## **OXFORDSHIRE COUNTY COUNCIL'S RESPONSE TO CONSULTATION ON THE FOLLOWING DEVELOPMENT PROPOSAL**

**Application no:** 23/02827/F

**Proposal:** Use of the eastern part of the southern taxiway and the adjacent Hush House building (Building 1368) for car processing operations plus associated works and portable buildings. Planning permission is sought for a 5 year period.

**Response Date:** 28/11/2023

# HEYFORD PARK - PROPOSED CAR PROCESSING AREA

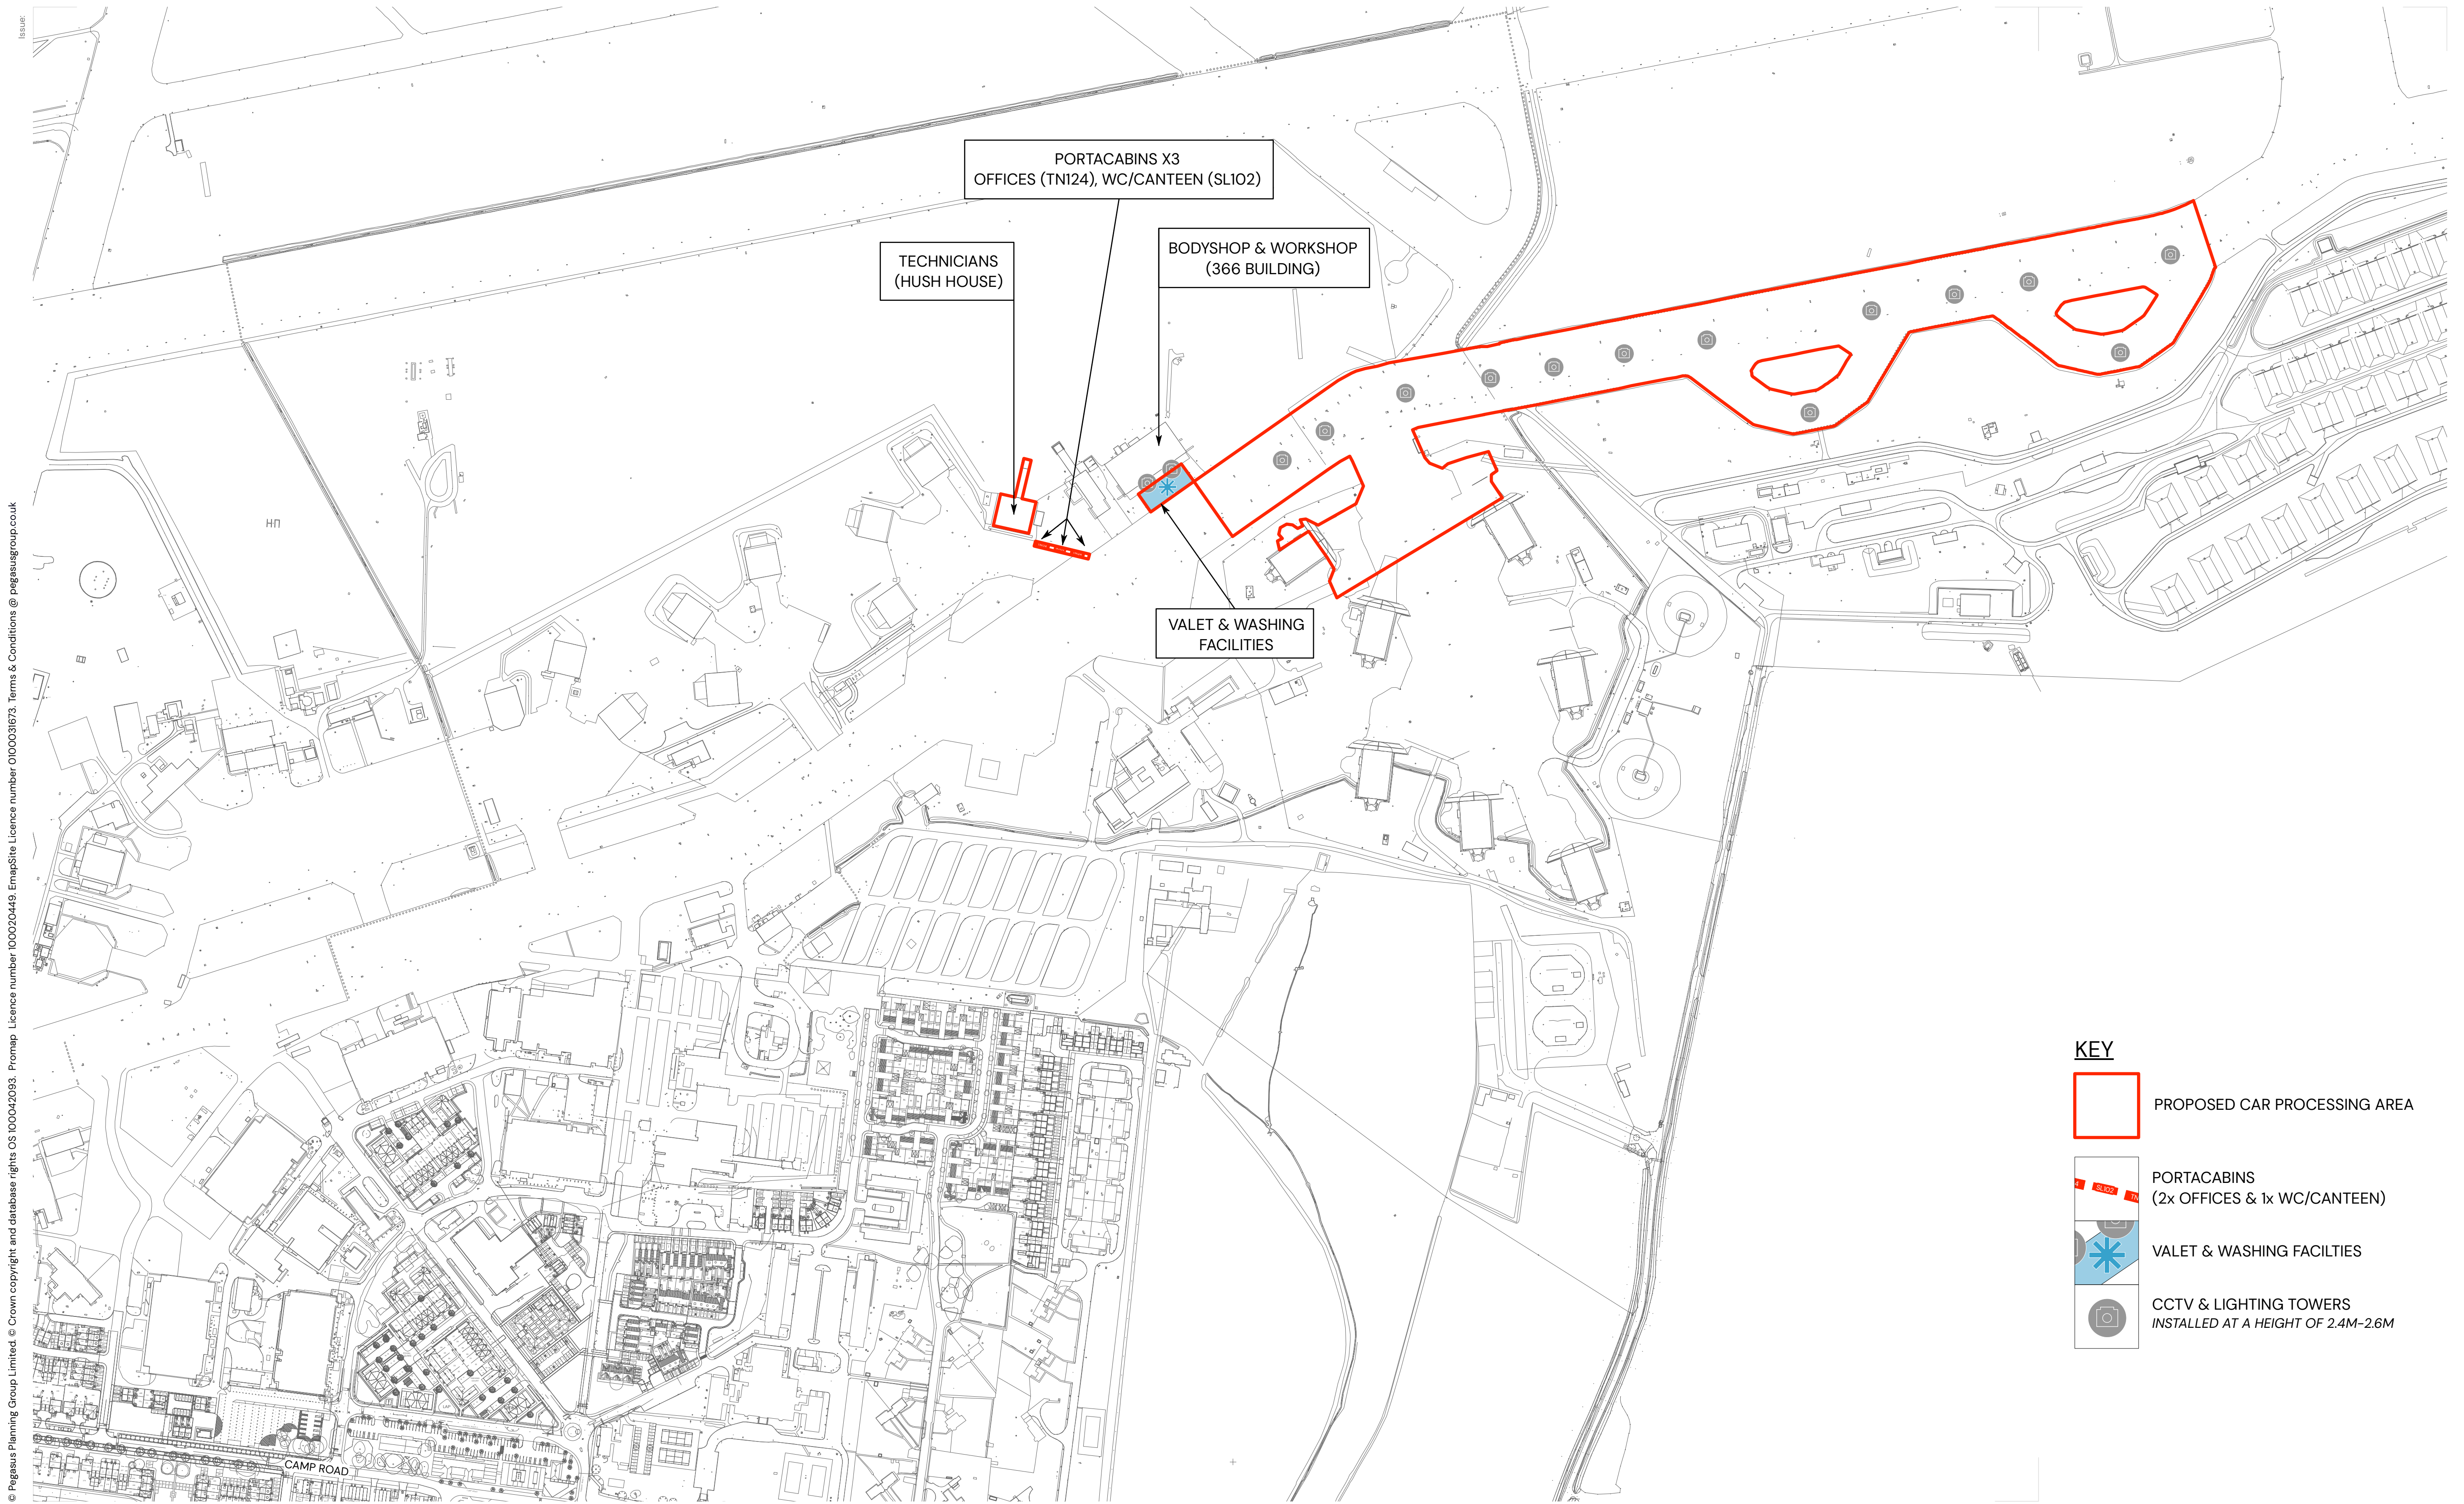
Given that it is now being proposed that operations will require up to 100 car transporter movements per day, that is a four-fold increase which will have an unacceptable impact, given that all access is via the gate at the western end of Camp Road. Camp Road passes through the village centre of Heyford Park, has traffic calming in the form of build-outs and vertical deflections, and accommodates relatively high volumes of pedestrians, cyclists and, in particular, schoolchildren walking and cycling between the school which is split between two sites on opposite sides of Camp Road.

It is realistic that the storage capacity can be increased from 7,869 (or 3,000) to 10,000, when the red line area is virtually the same as before?

As these proposals will intensify the use of the car storage area and increase HGV movements, it is considered that this triggers the need for the Bus Route and Primary HGV Access road to be delivered first. Furthermore, the proposals include the occupation of the Hush House building, which is within Area A.

If the application is approved and car storage is allowed for a period of five years, this may have consequences for the future delivery of the Bus Route and Primary HGV Access, which may be triggered by other requirements such as the provision of the primary school. The western half of the red line area will be required for the construction of this road. How will the car storage use be curtailed to enable construction to take place?
